Planning Review:

Project **ADDITION & REMODEL WOODMOOR IMPROVEMENT ASSOC 1691 WOODMOOR DRIVE** Subject **SITE PLAN**

Subject SITE PLAN

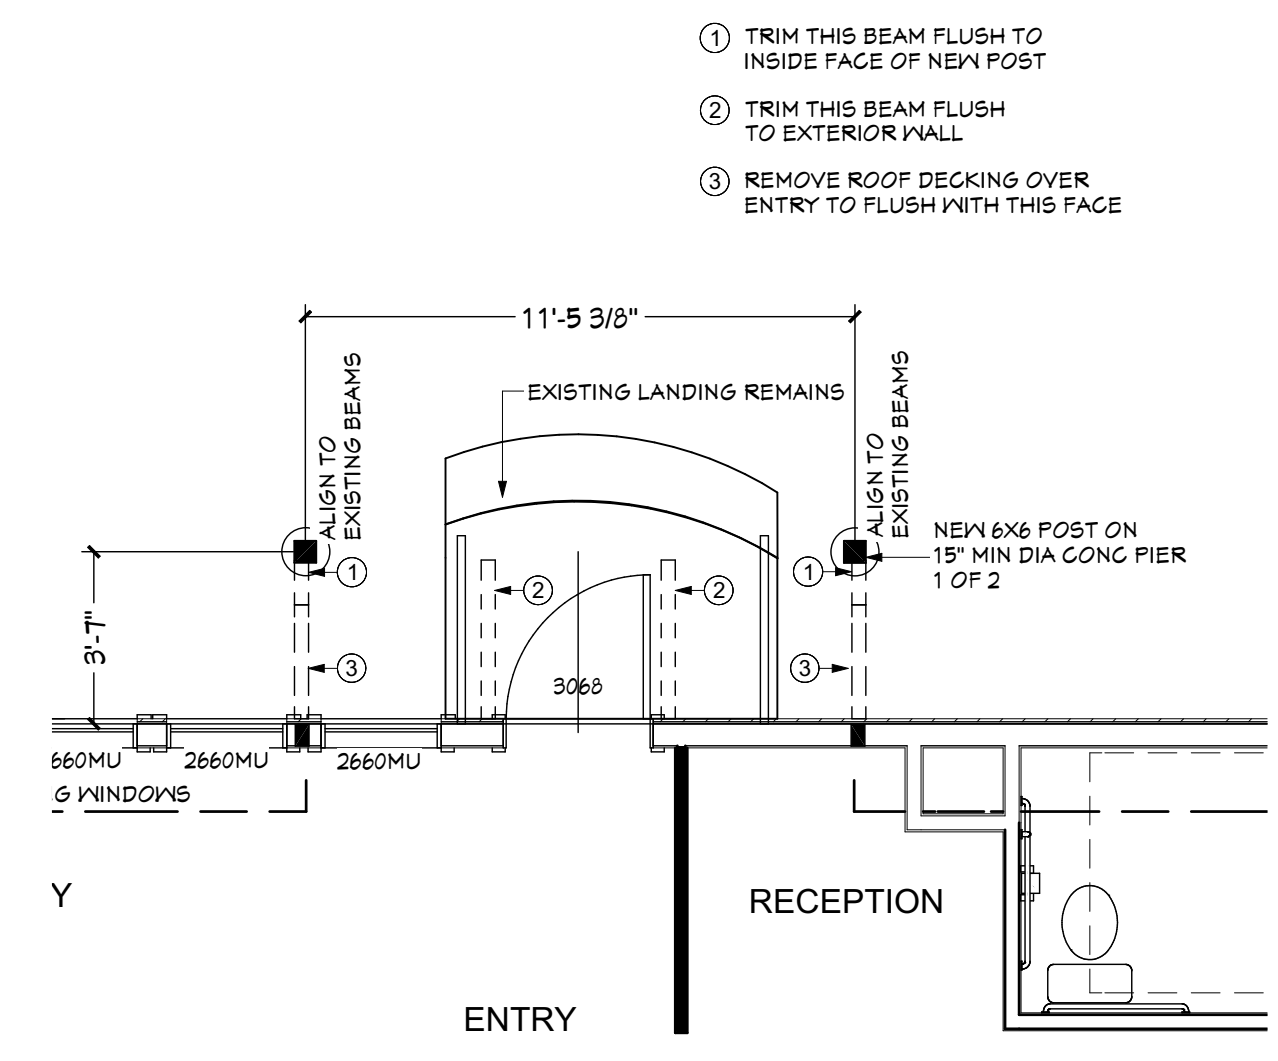
1. Please include a contact person with a phone number and email address for the Woodmoor IA.
2. The Property address shall be included next to "address" under site data- 1691 WOODMOOR DR

3. Show existing land use and zoning – indicate that it is not changing.
4. Total gross building square footage – is this proposed entryway 784sf? Please check the existing vs. the proposed sqft and correct. This looks like it was left over from the last submittal in 2019.

5. Include parking computations (required, provided, etc.) Include a note that the parking is contained on a common parcel and not on the subject property. The previously stamped plans (4/2019), which you included, has the parking information on it, please include this information on the proposed site plan.

6. Please include a graphic scale and the date of the drawing.
7. Include a clear vicinity map.
8. Please include the location of all ADA spaces, ramps and signs, including ADA pathways – the satellite view shows the ADA stall are in other locations.

9. Please cloud the proposed entryway
10. Please include a one or two sentence description of the proposed project.
11. Include parcel number for all 3 parcels.

FRONT ELEVATION 1/16" = 1'-0"

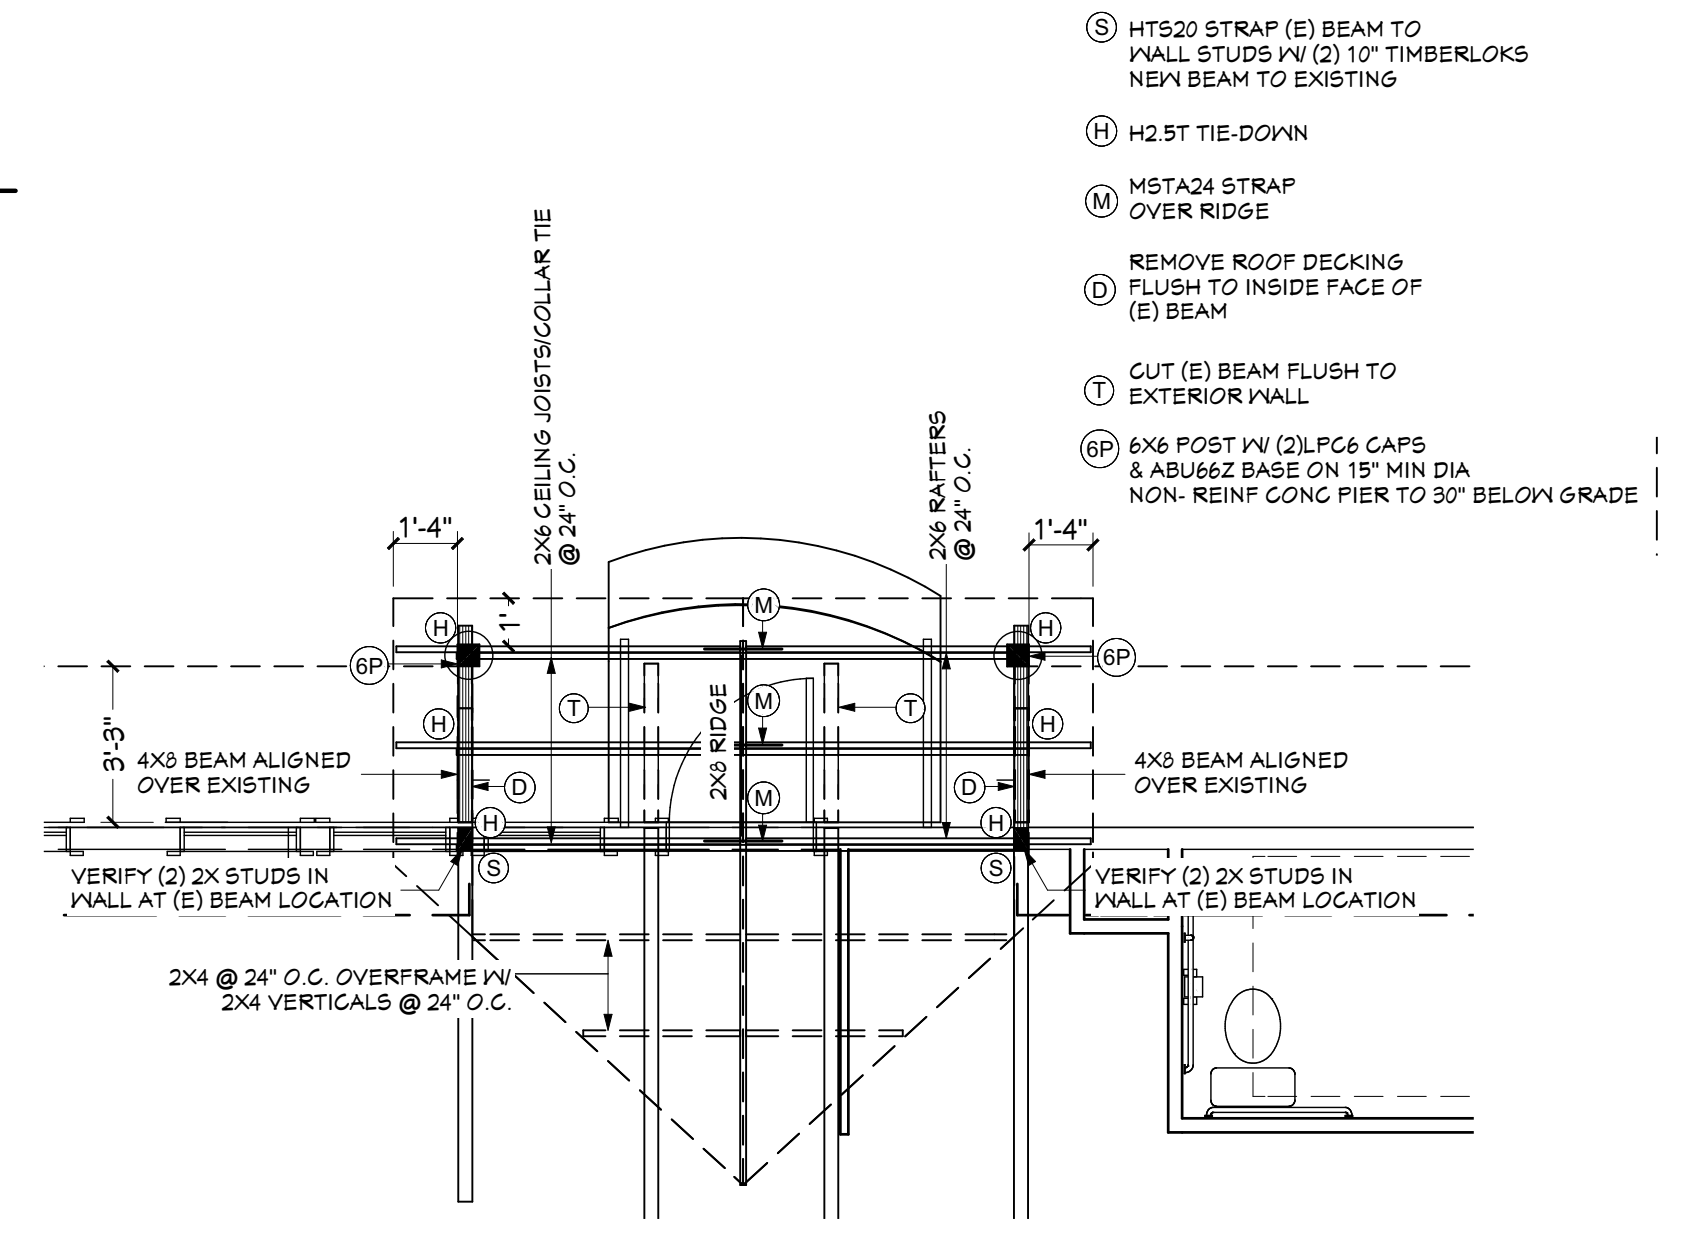
12. Include the front and side elevation drawings on the plans
